TOWN AND COUNTRY PLANNING ACT 1990

FULL

Reference: H14-0811-21 **Date of Decision:** 13th October 2021
Applicant: Scottpark Developments Ltd.
Office 10 Welland Workspace
10 Pinchbeck Road
Spalding
PE11 1QD
Location: Adj. 47 Milestone Lane Pinchbeck Spalding
Description: Residential Development - Erection of Dwelling

NORTH EAST ELEVATION

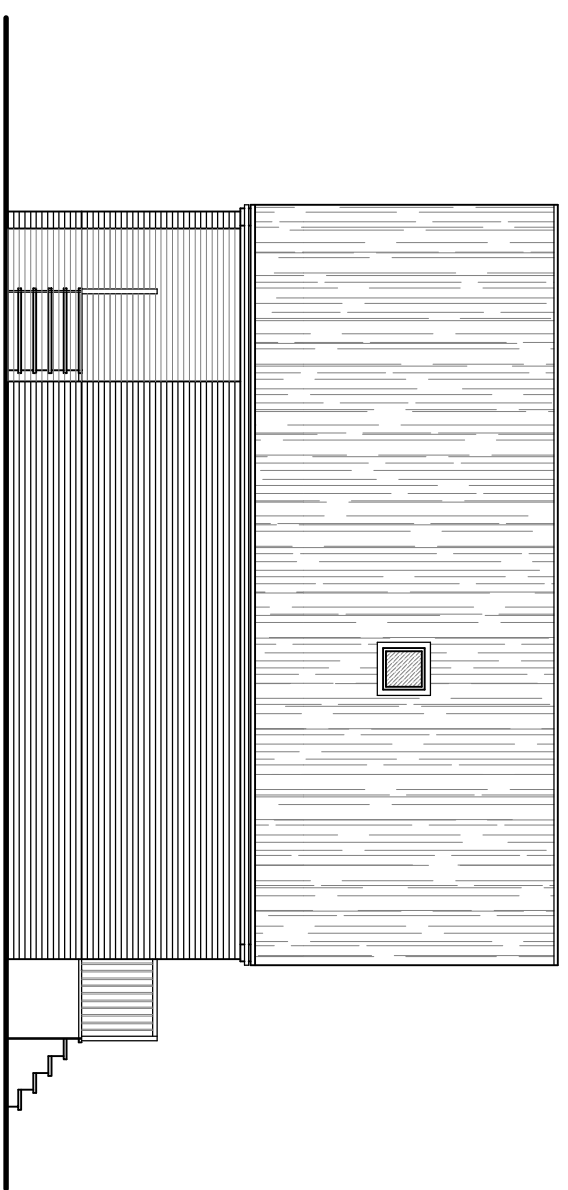
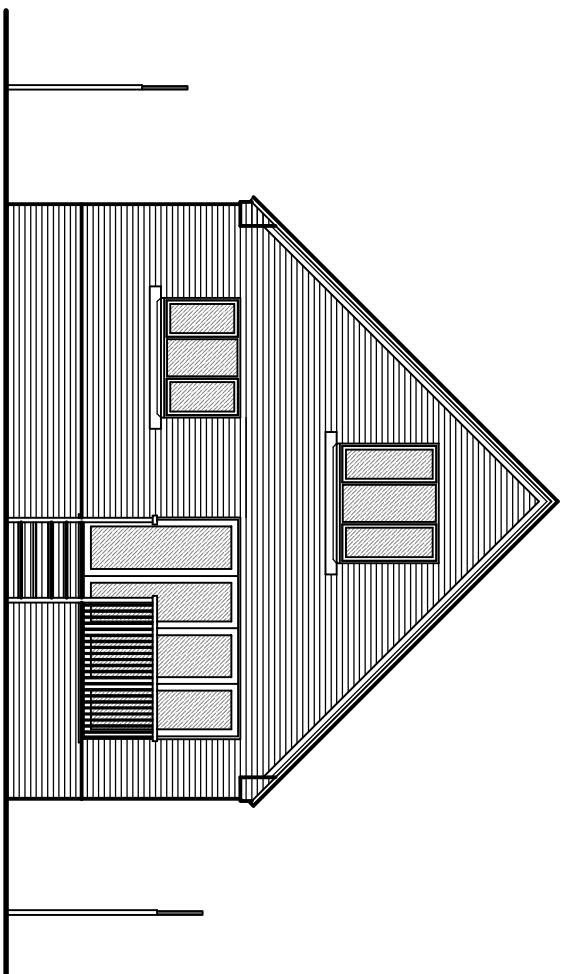
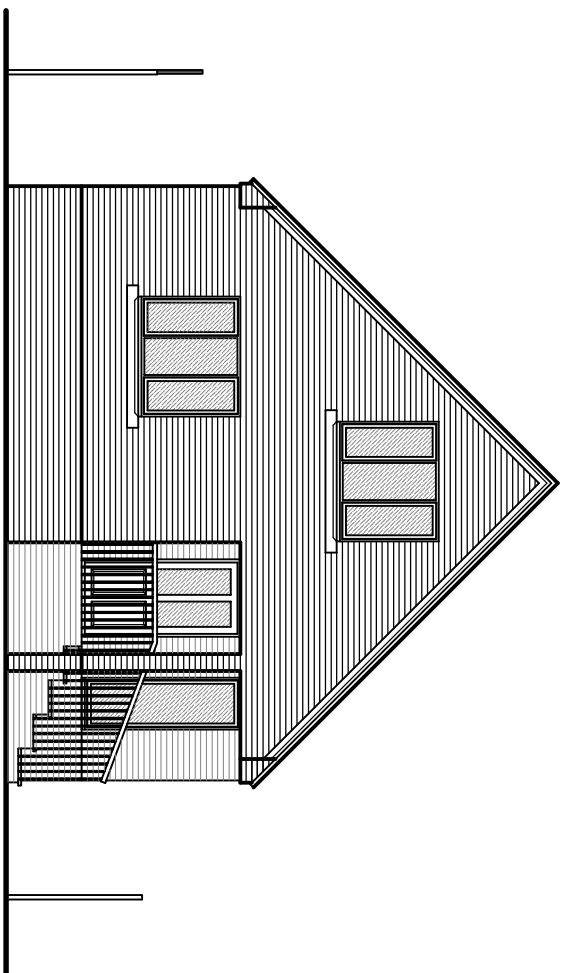
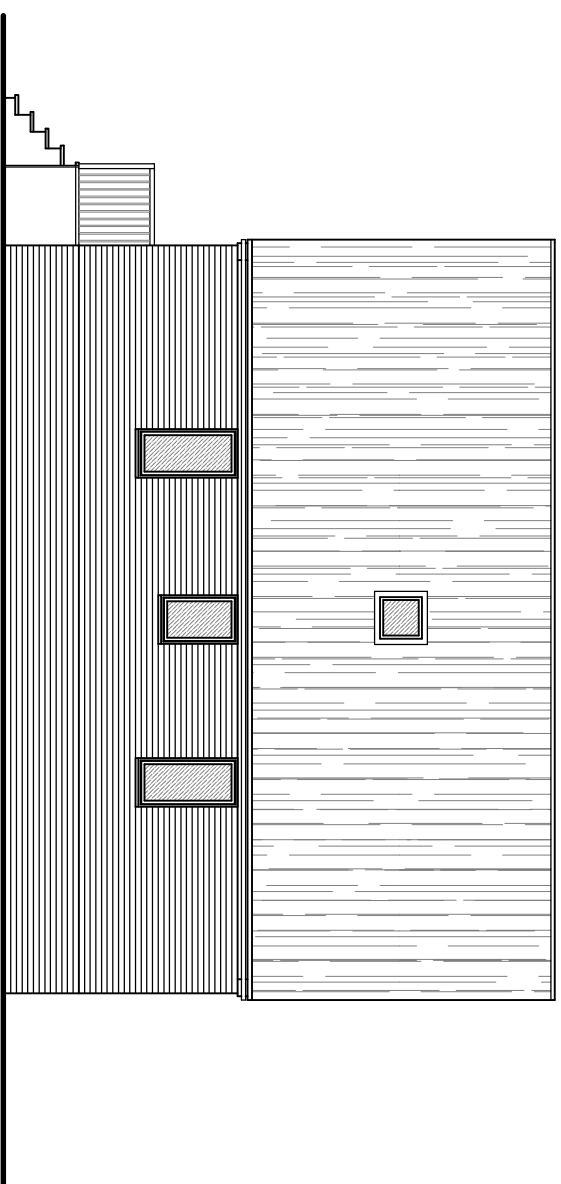
The impact is further exacerbated by the need to raise finished floor levels to 1.0m above existing ground level due to flood risk, which has been addressed by incorporating stepped access. This is at odds with the appearance of existing dwellings in the vicinity.

Furthermore, the proposed boundary treatment to the sides and rear of the dwelling (1.8m closeboard fencing with 300mm trellis above) is not sufficient to prevent a material overlooking aspect of the garden to no. 47 Milestone Lane given the need to raise finished floor levels by 1m.

SITE PLAN.
1/250.

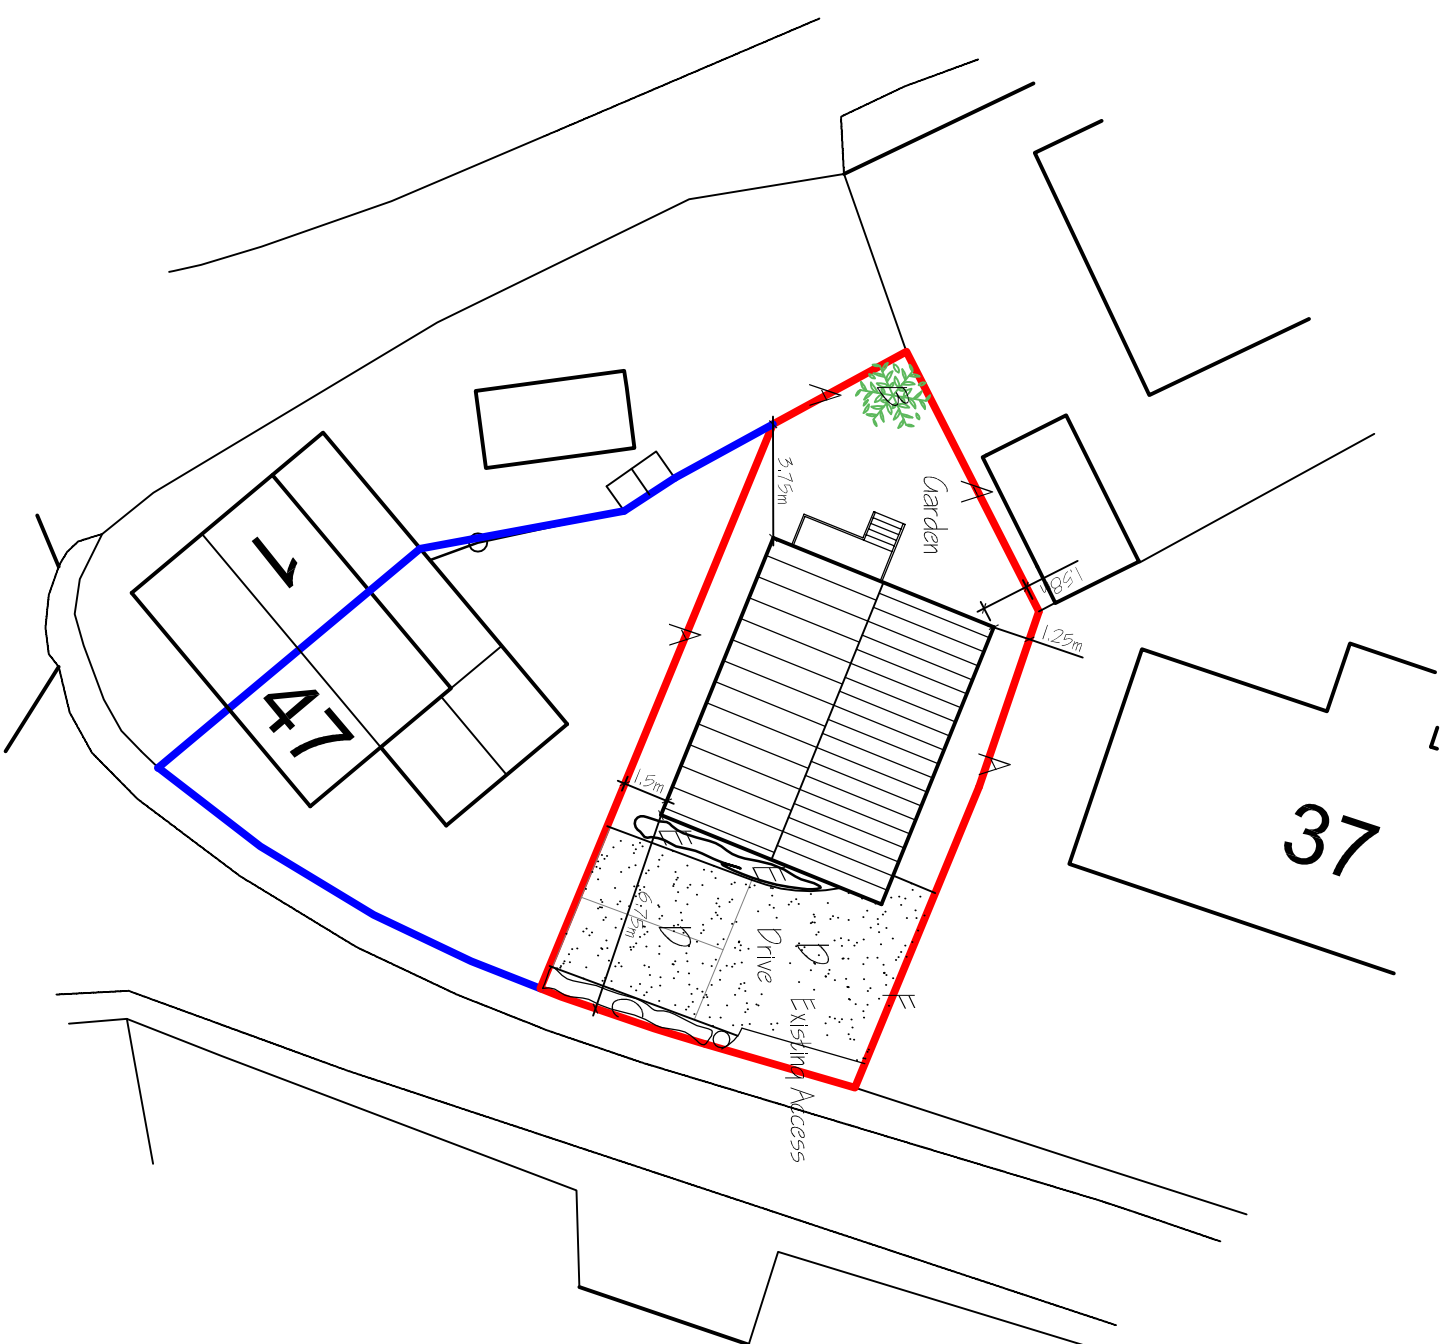
- 1 The proposed dwelling would constitute an unacceptable form of cramped development out of keeping with existing development in the area by virtue of existing residential development being sited within larger plots and the application site offering limited external space in comparison.

- 2 In the absence of a daylight/sunlight study, the Local Planning Authority is unable to determine whether the impact of the proposed development on the property immediately to the north of the application site would be acceptable.
